Morris Goding  
Access Consulting

5 October 2018

**RE: Sandstone Precinct Education Building – Accessibility statement for application for modification of consent**

**LANDS BUILDING - LEVEL 06,
EDUCATION BUILDING -
LEVEL 05**

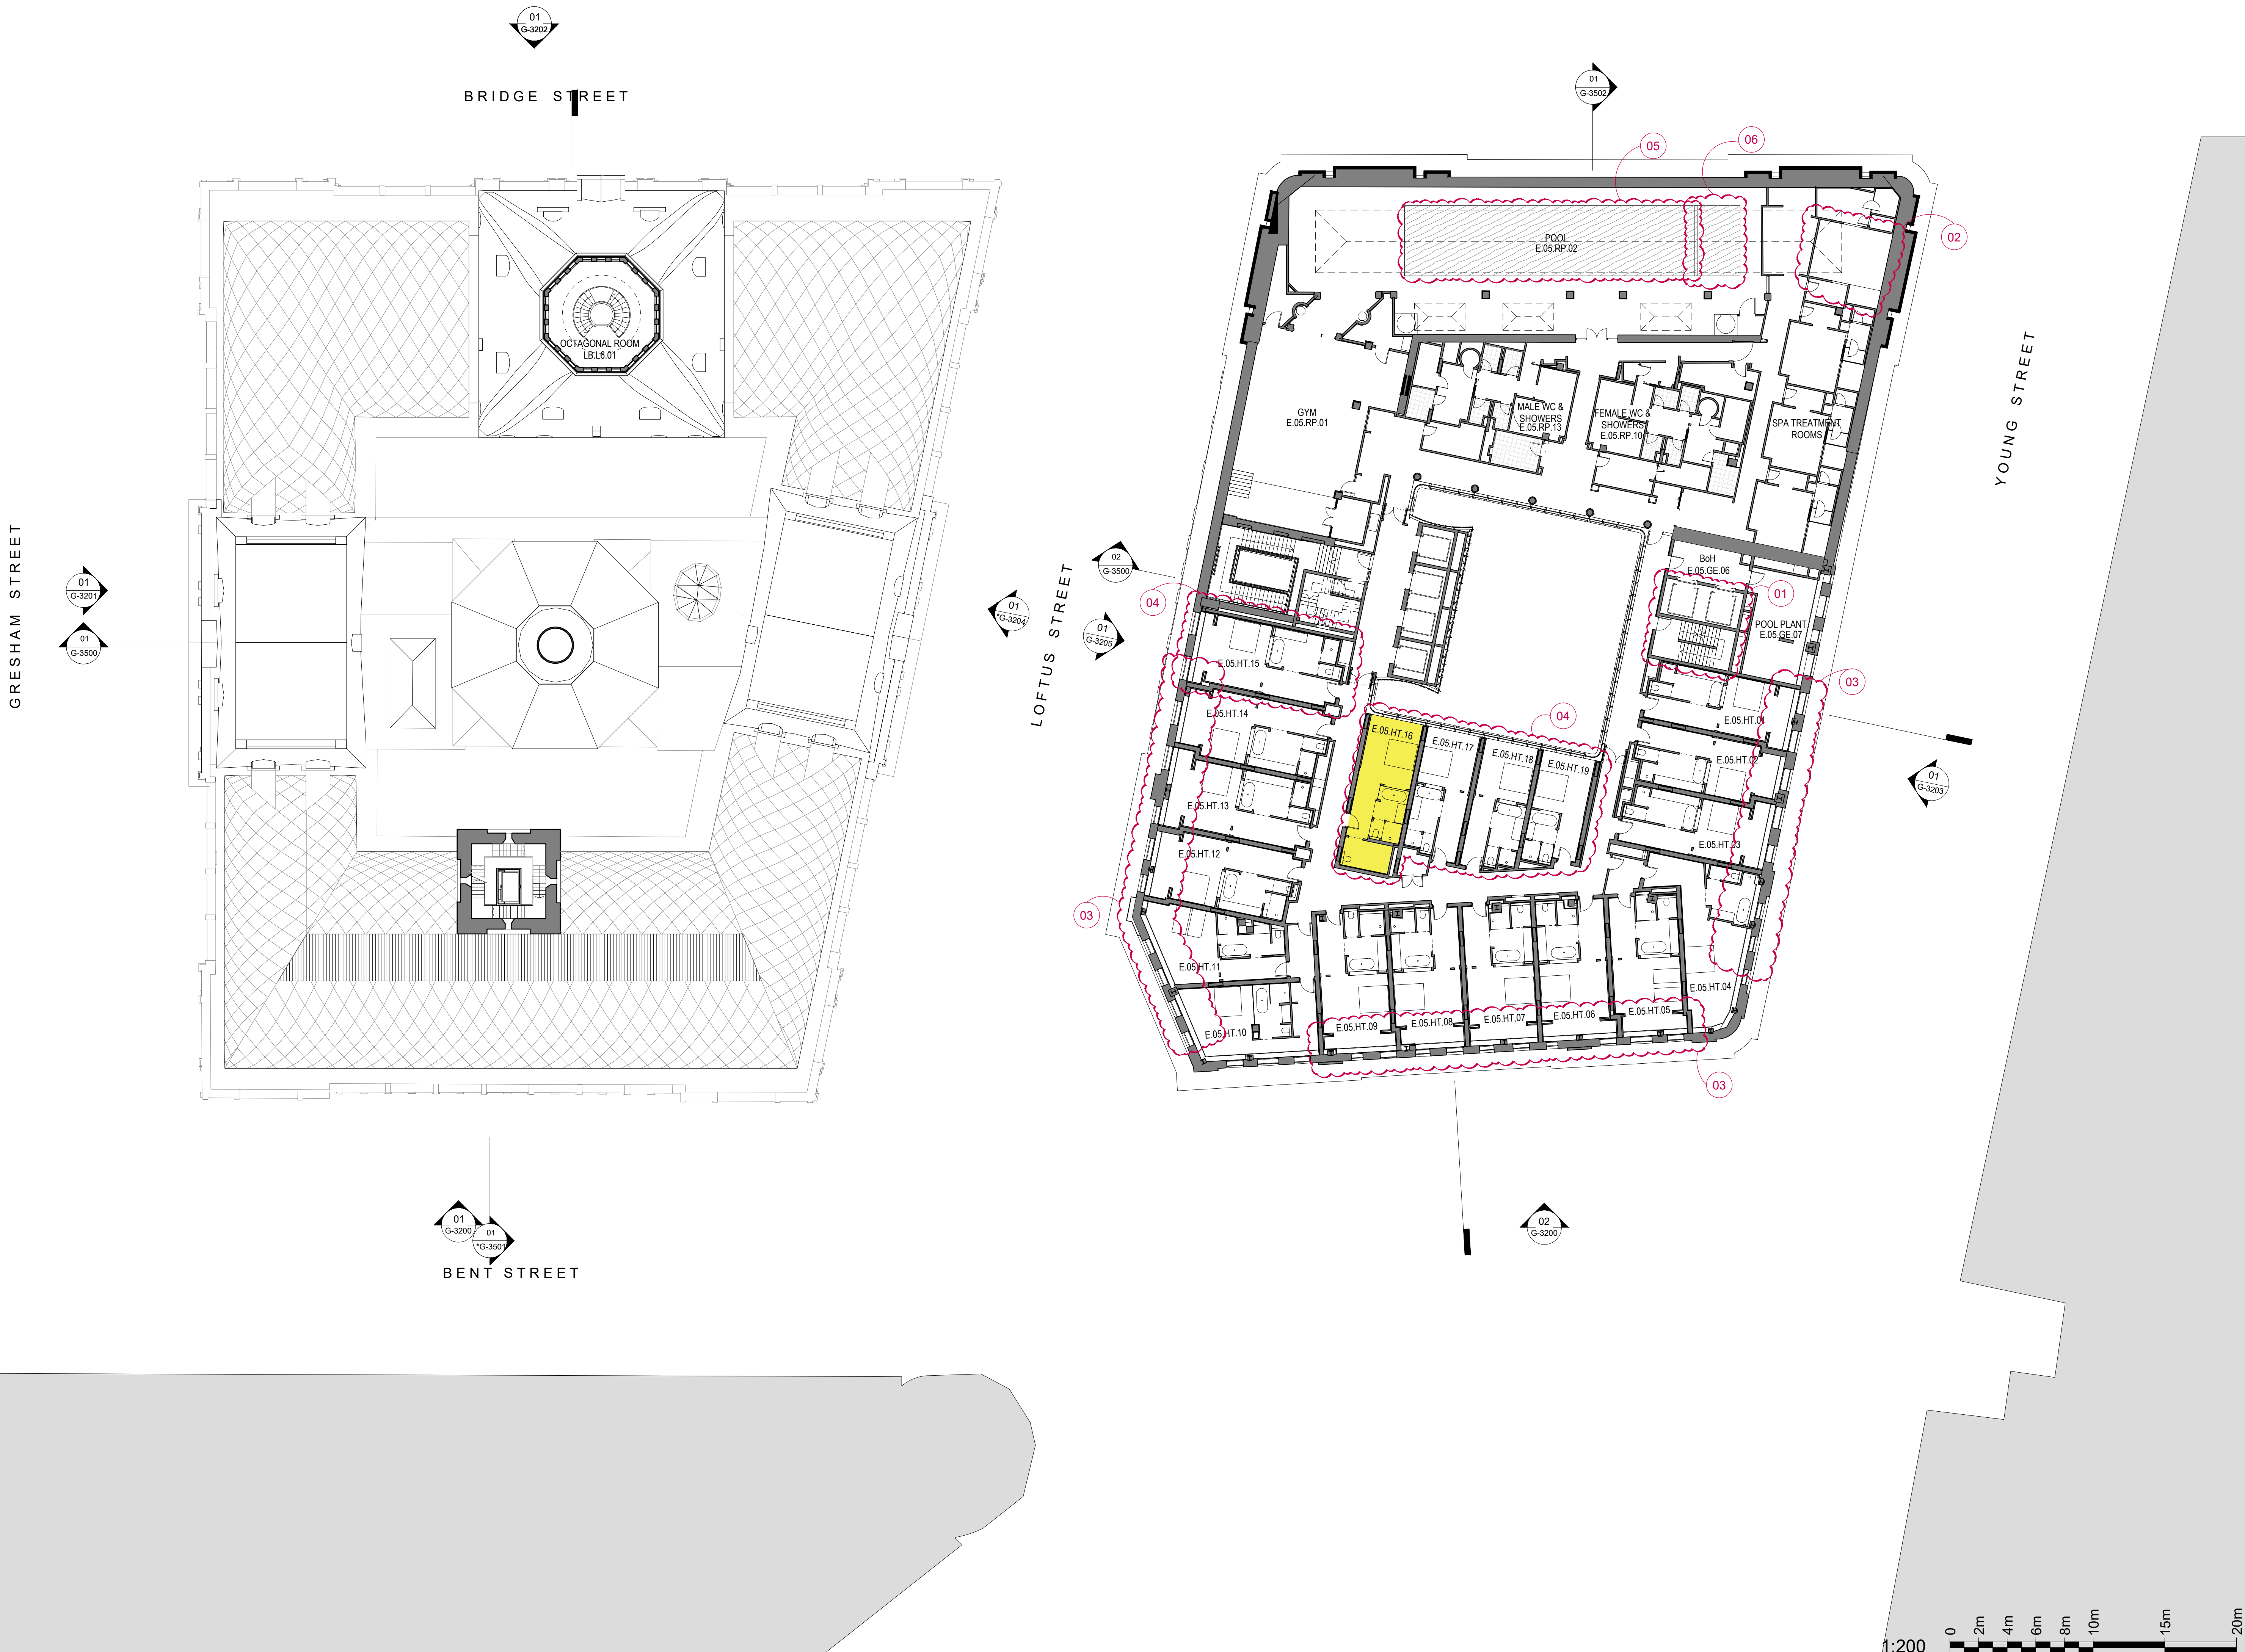
There is a Wellness Centre at the northern half of Level 5, as shown on drawing SP-DA-G-2505-04. The provision of access to the Wellness Centre under the modified scheme is achievable for compliance with the DDA Premises Standards 2010 and the BCA.

Under the former scheme there were, within the Wellness Centre, multiple changes in flooring levels. Under the modified scheme, the changes in flooring levels will be reduced to a minimum. This change will be advantageous for access for people with a disability. Access for compliance with the DDA Premises Standards 2010 and the BCA within the Wellness Centre under the modified scheme will be achievable during design development.
